SITE PLAN

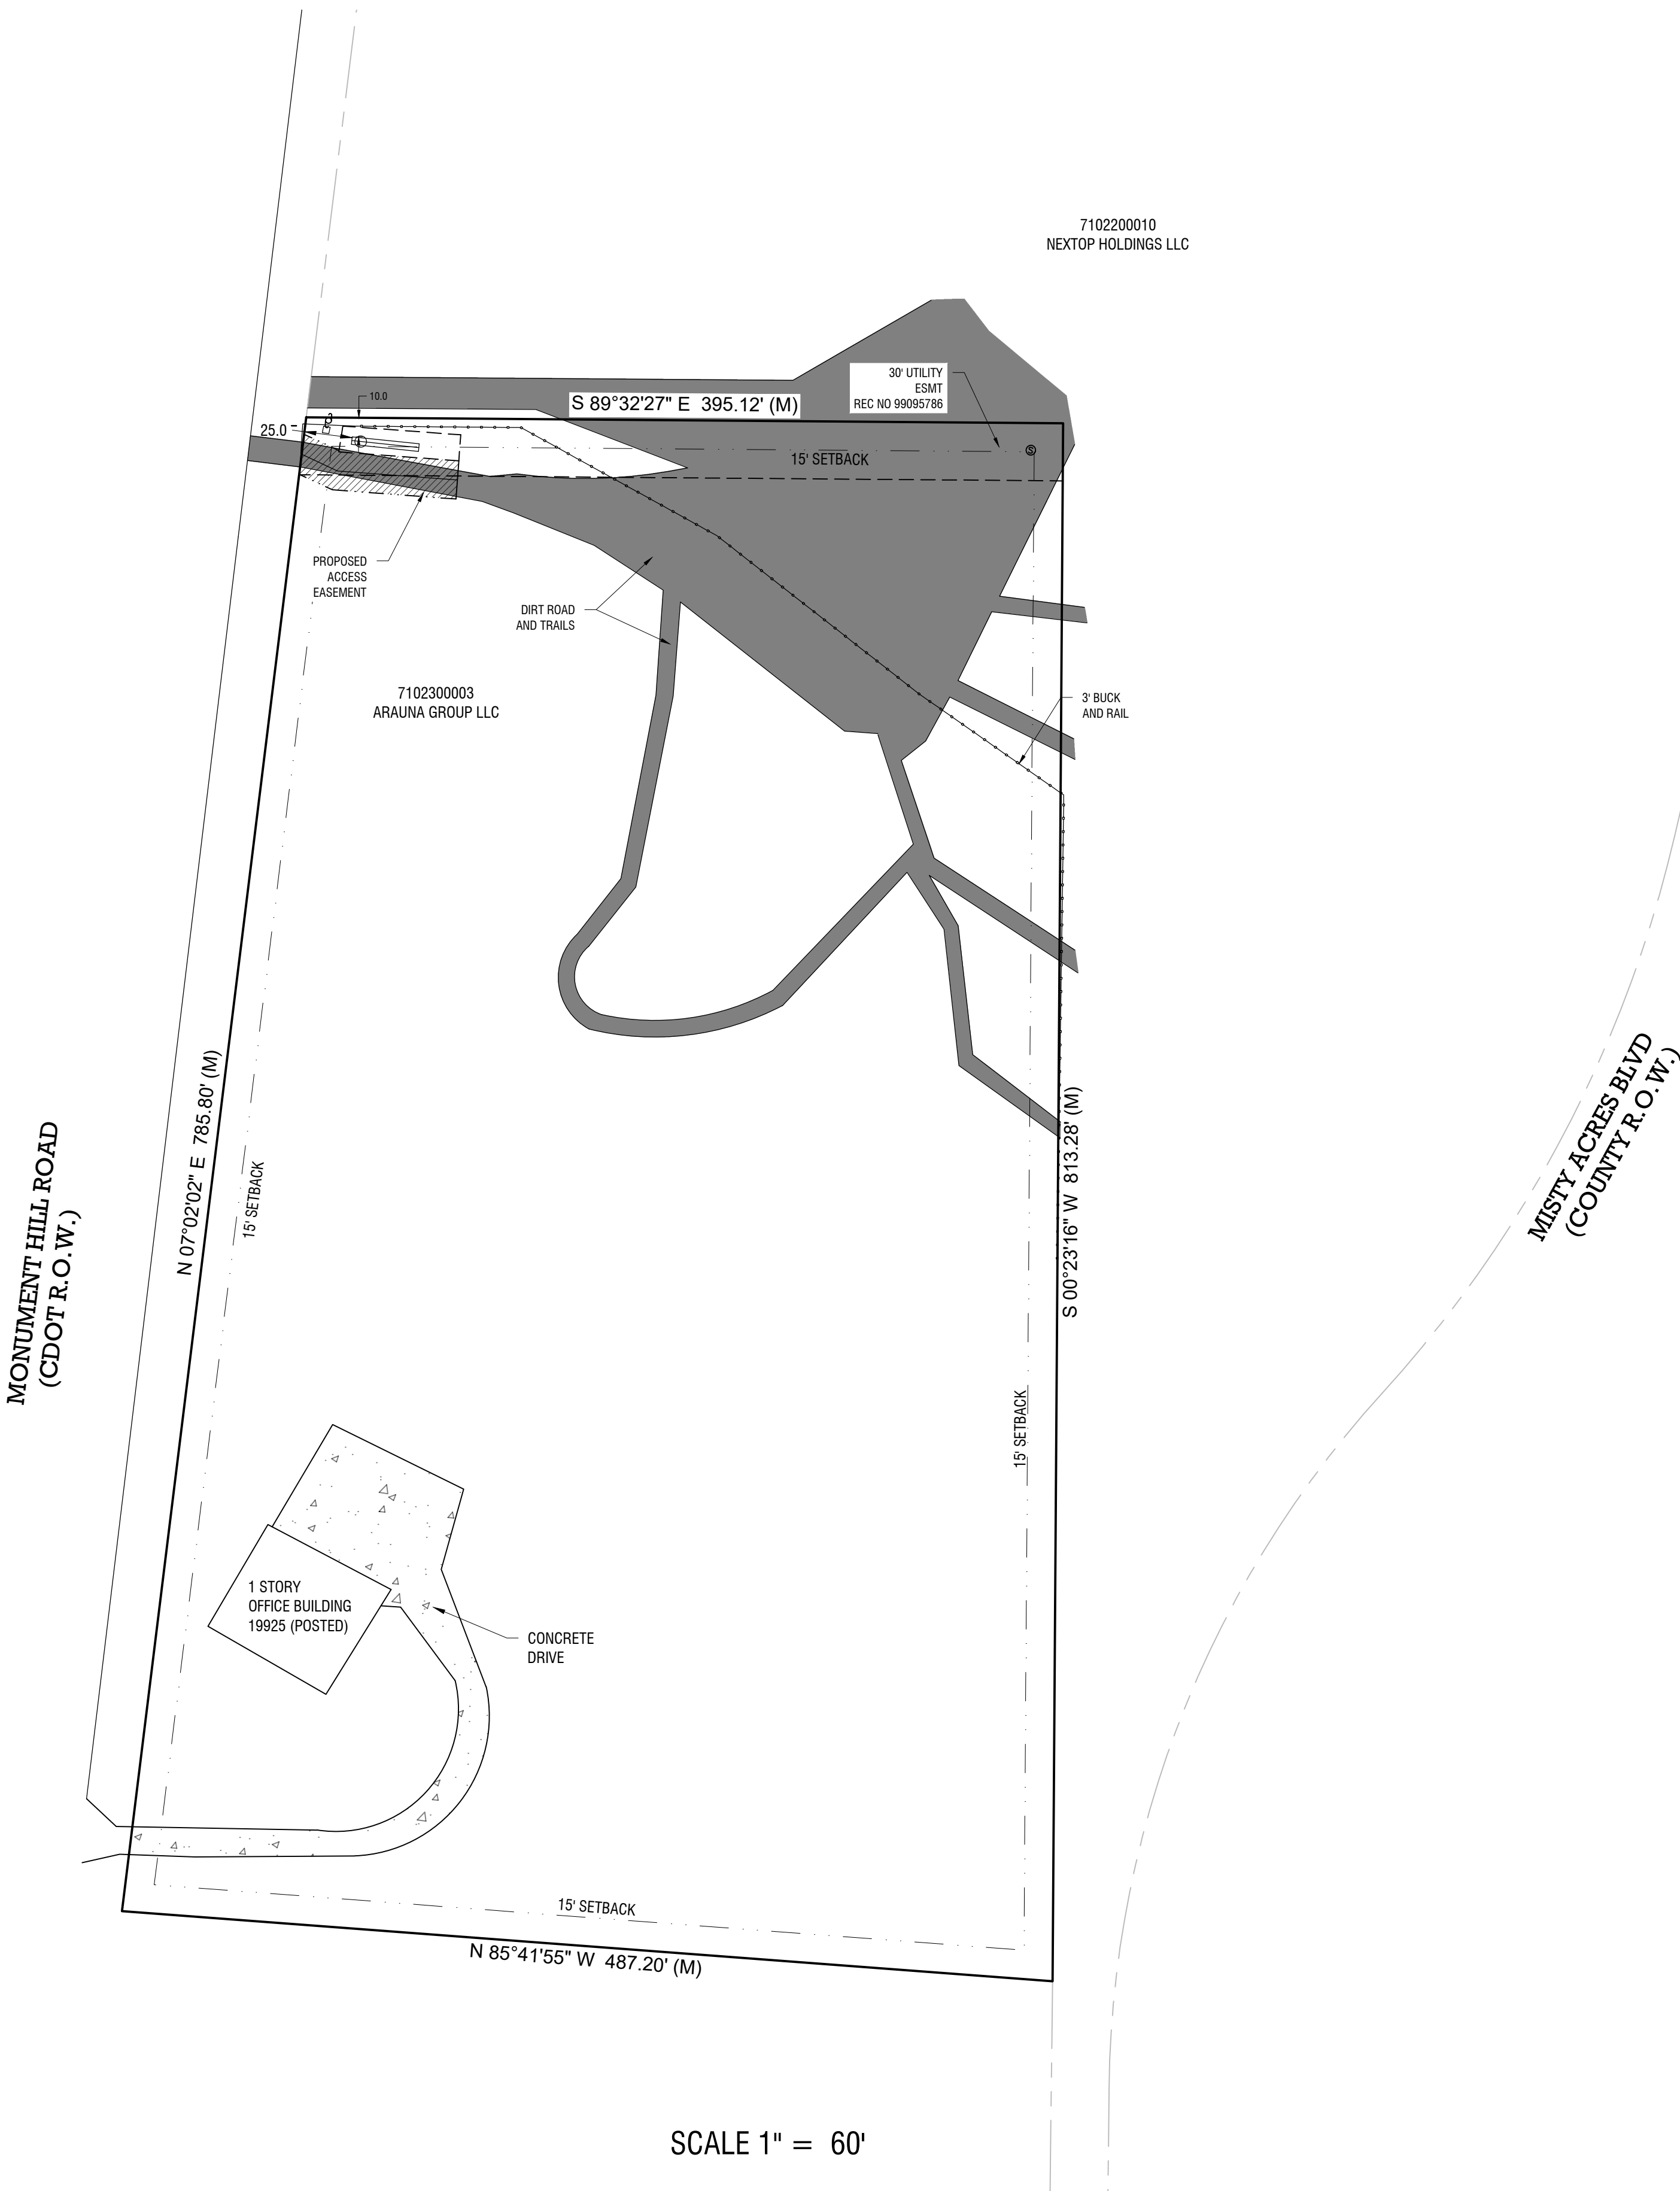
- Please depict a Vicinity map which shows the subdivision in relation to section lines and existing or proposed arterial or collector roadways
- Please depict location and dimension of all property lines, right of way, and all existing and proposed easements
- Please depict setbacks of proposed structure to property lines and any other structures on the property
